**KIRKLEES METROPOLITAN COUNCIL  
INVESTMENT & REGENERATION SERVICE**

Reference No:	<b>2024/44/92847/W</b>
Site Address:	Clover Farm, Scout, Woods Mount, Marsden, Huddersfield, HD7 6LD
Description:	Discharge of details reserved by condition 9 (passing places) on previous permission 2023/90469 for demolition of stables/food store and commercial workshop and erection of one dwelling for holiday let
Recommending Officer:	Molly Storer

**DECISION – APPROVE DISCHARGE OF CONDITION 9**

## DISCHARGE OF CONDITIONS

Plan Revised A
scale 1:1000 @ A3
reference DBAR/1024/06A

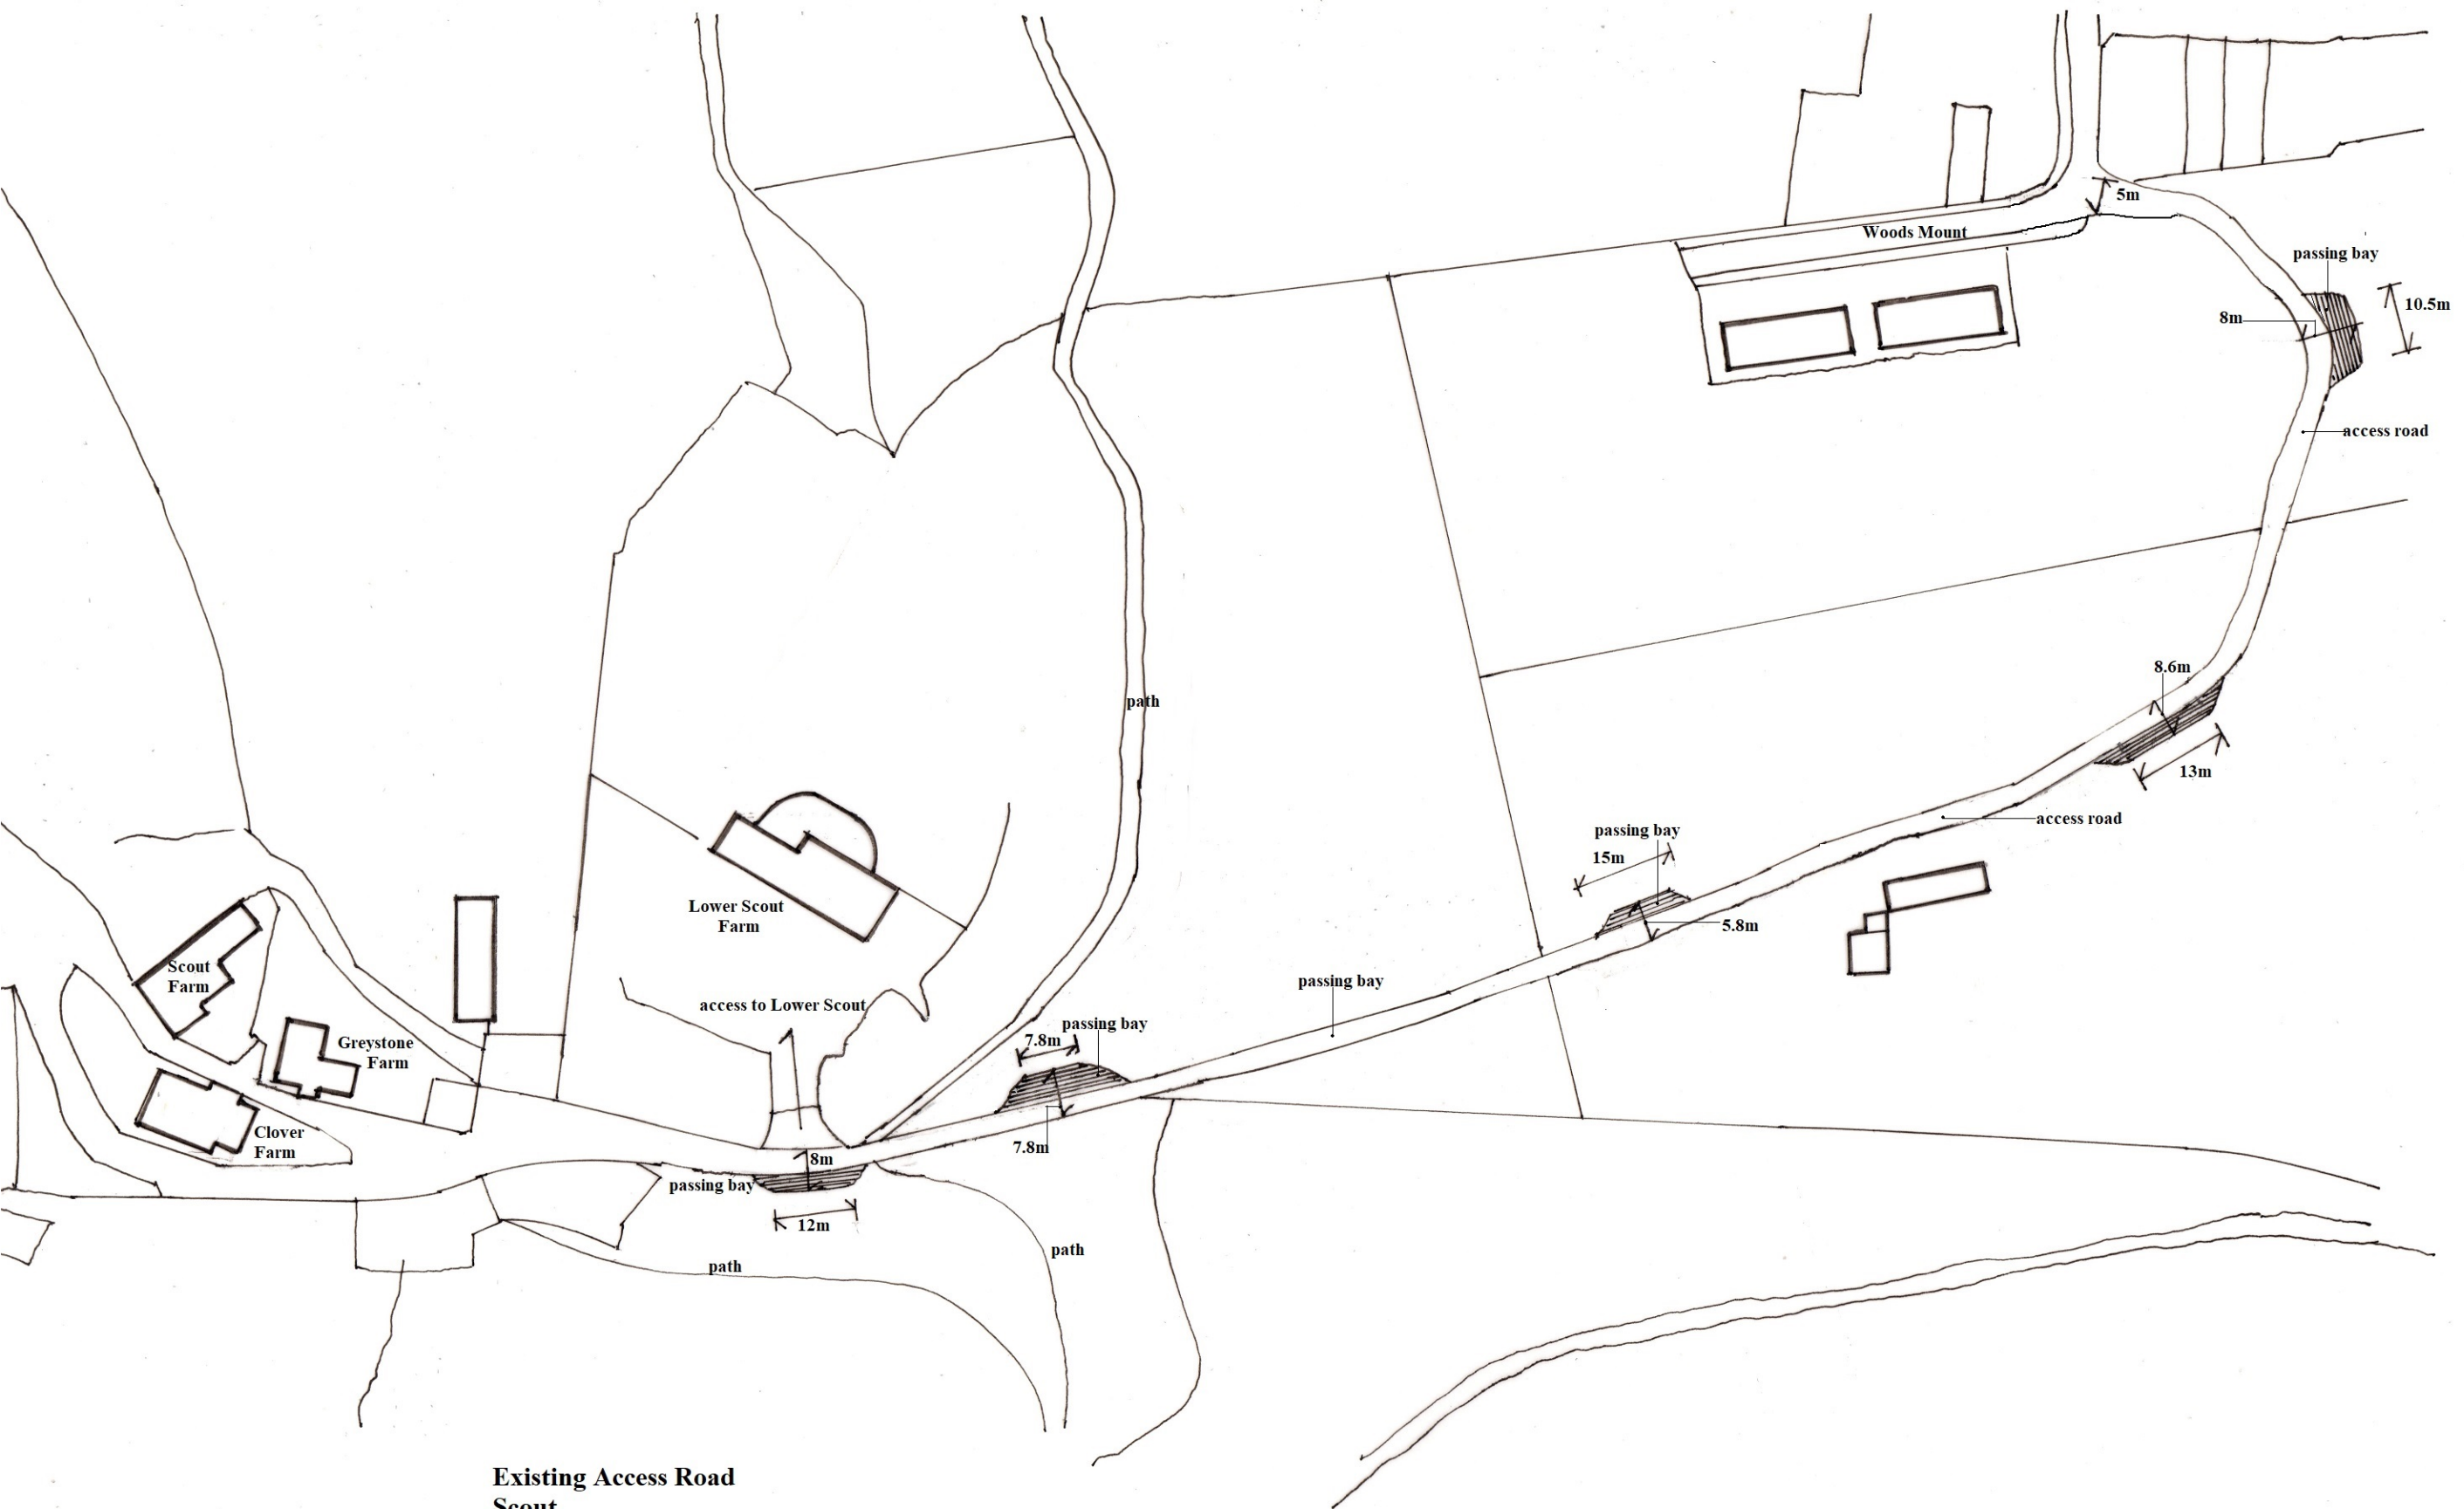
*‘Drawing No DBAR/1024/06A Revision A has provided suitable details of the location and size of the vehicle passing places along the access track leading to the development from Woods Mount. The drawings as submitted are therefore acceptable and condition 9 can be discharged.’*

Taking account the response from KC Highways, the content of the submitted plans and confirmation of details showing the location and size of the vehicle passing places, it is considered that this information is sufficient for the purposes of condition 9 on planning permission 2023/90469. This condition will be discharged by the provision of the approved passing places prior to occupation of the holiday let, and their retention thereafter.
